Tel: 01895 250230  
Case Officer: Ed Laughton  
Email: [elaughton@hillingdon.gov.uk](mailto:elaughton@hillingdon.gov.uk)  
Date: 6th January 2022  
Our Ref: 924/PRC/2021/187

**RE: Extensions to care home facility**  
**SITE: Denville Hall Ducks Hill Road Northwood**

**Pr. view 3: Restaurant - Front view**

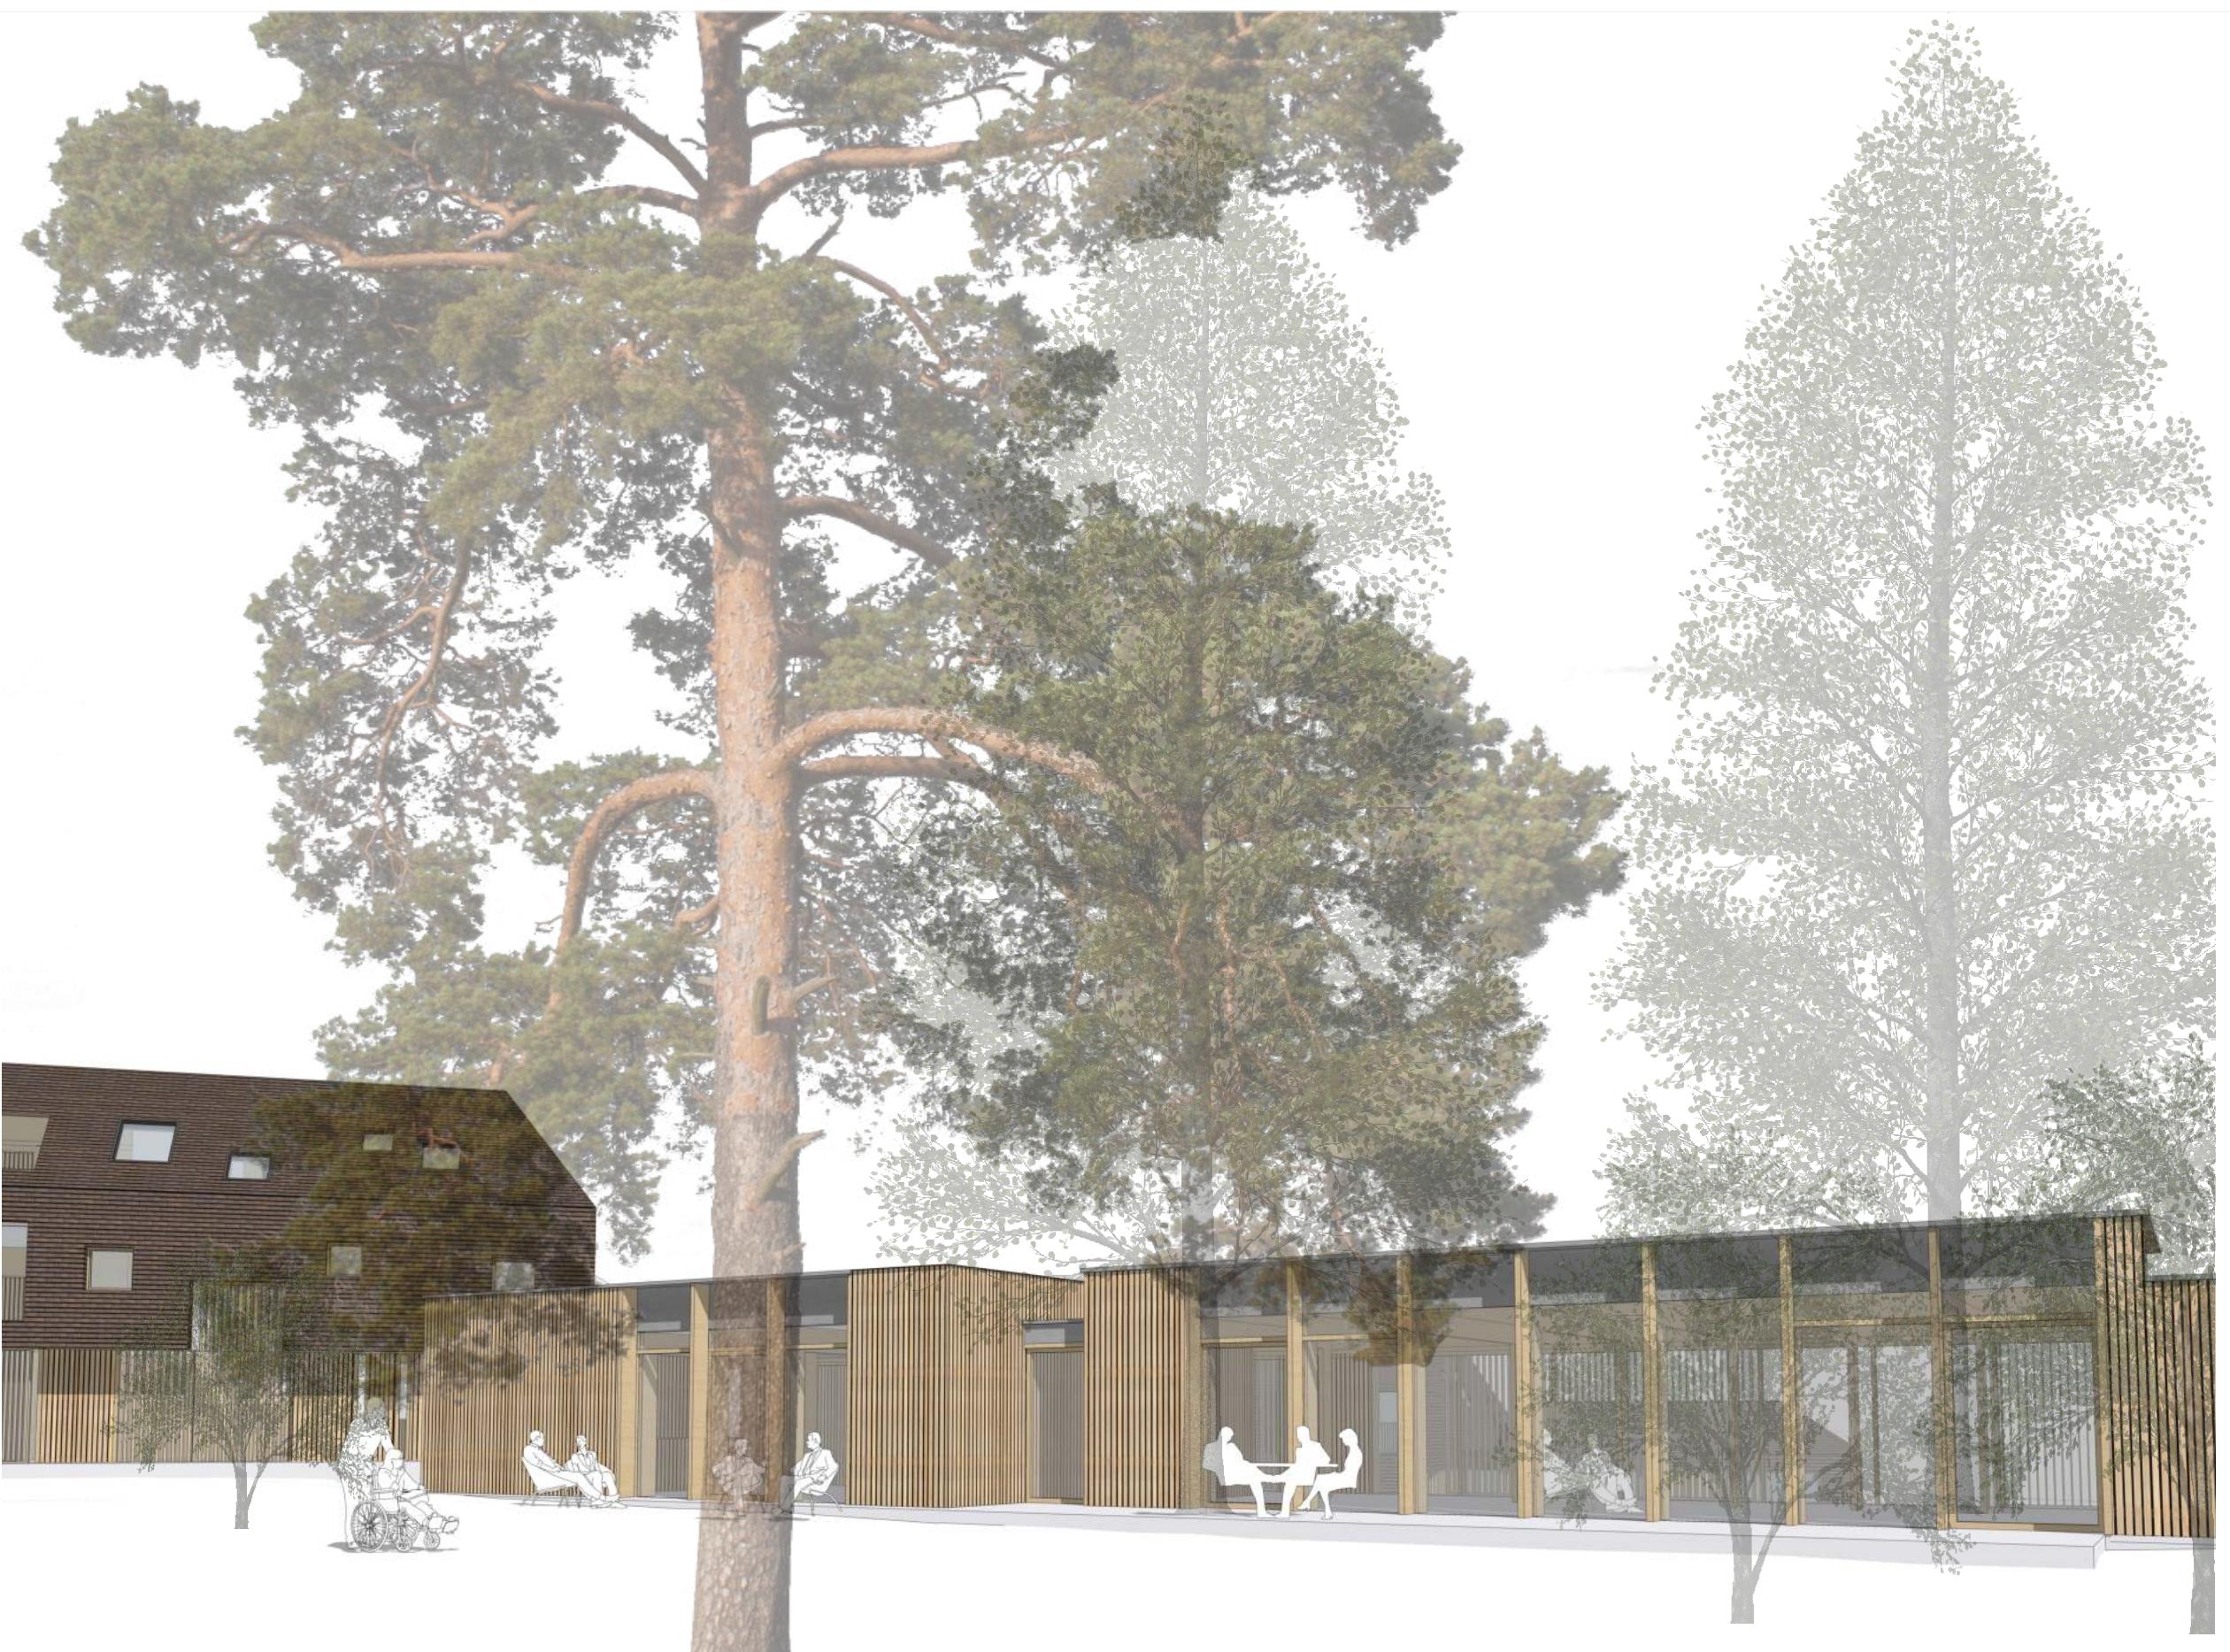
Building C would be considered to be an extension to the Locally Listed Building. Whilst it would not harm any historic built fabric it would result in the site being further developed. The proposed addition would have some impact on the setting of the non-designated heritage asset however, a compromise from a historic environment perspective could be met considering the lightweight appearance of the structure.

# Link Corridors

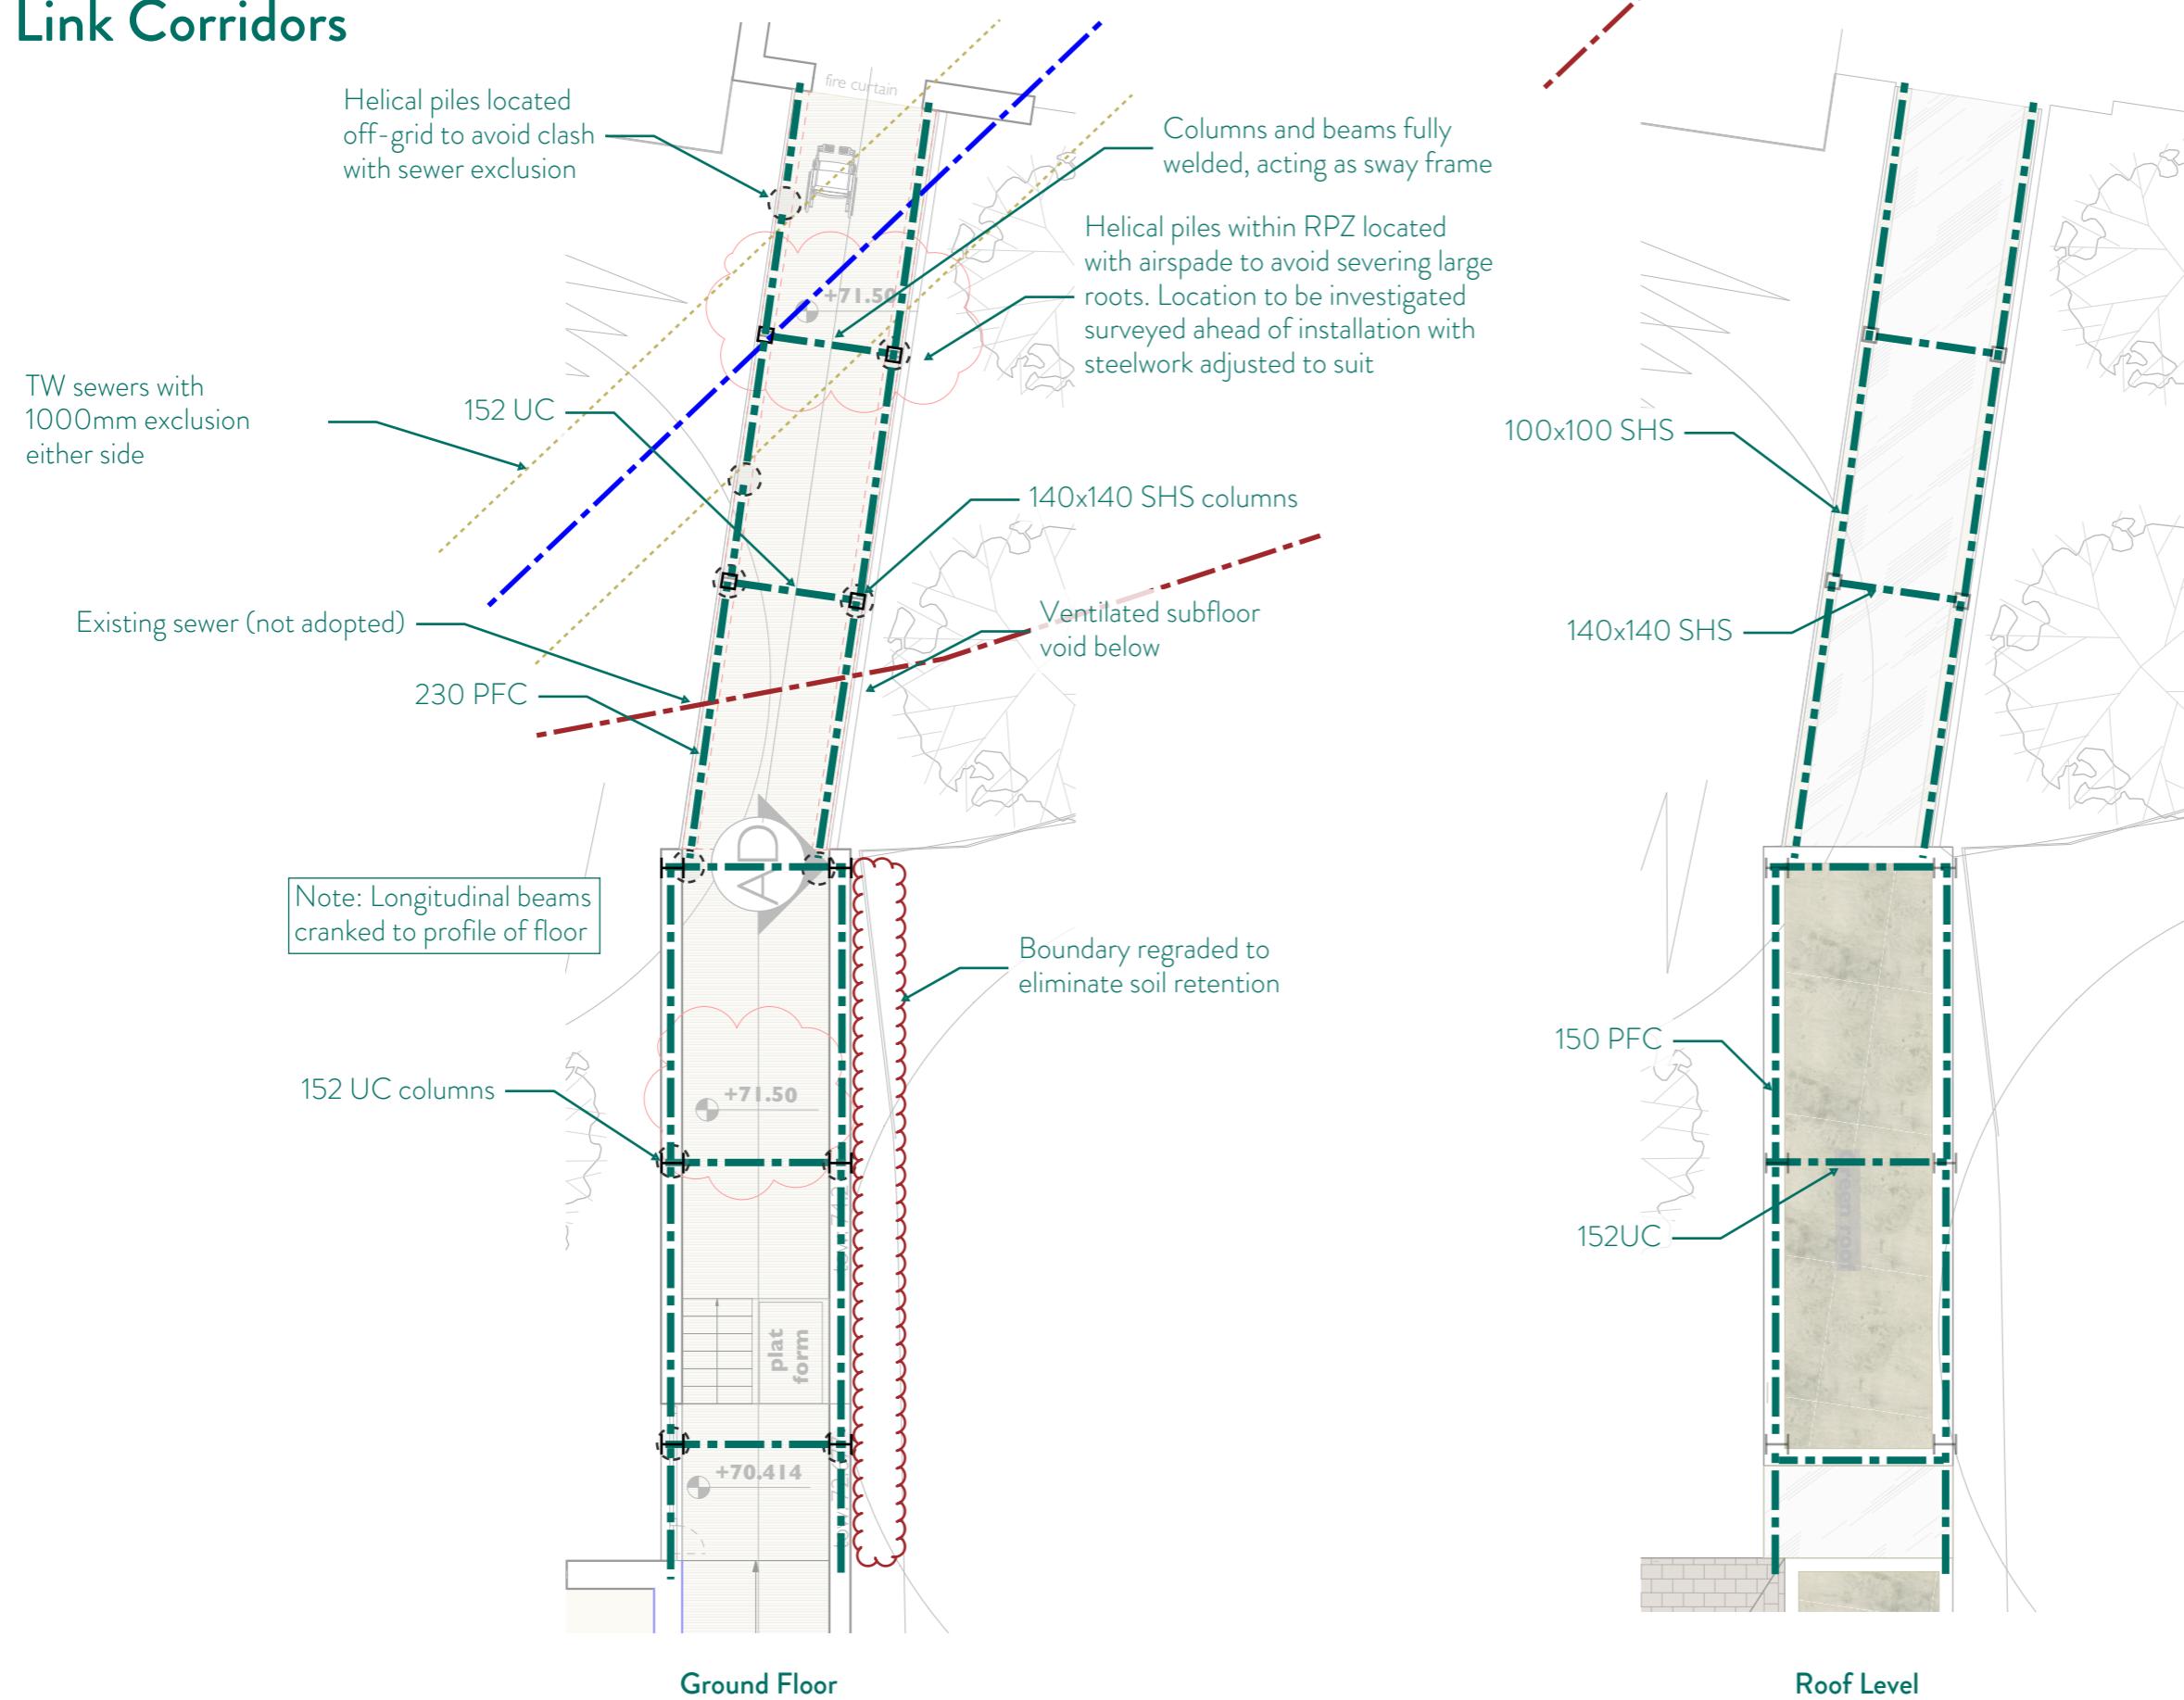
The proposed link between Building C and Building A is not considered to be acceptable to the Council's Conservation and Design Officer. It would result in development sprawling across the site. A physical separation is important in order to maintain actual openness to the site not just visually.
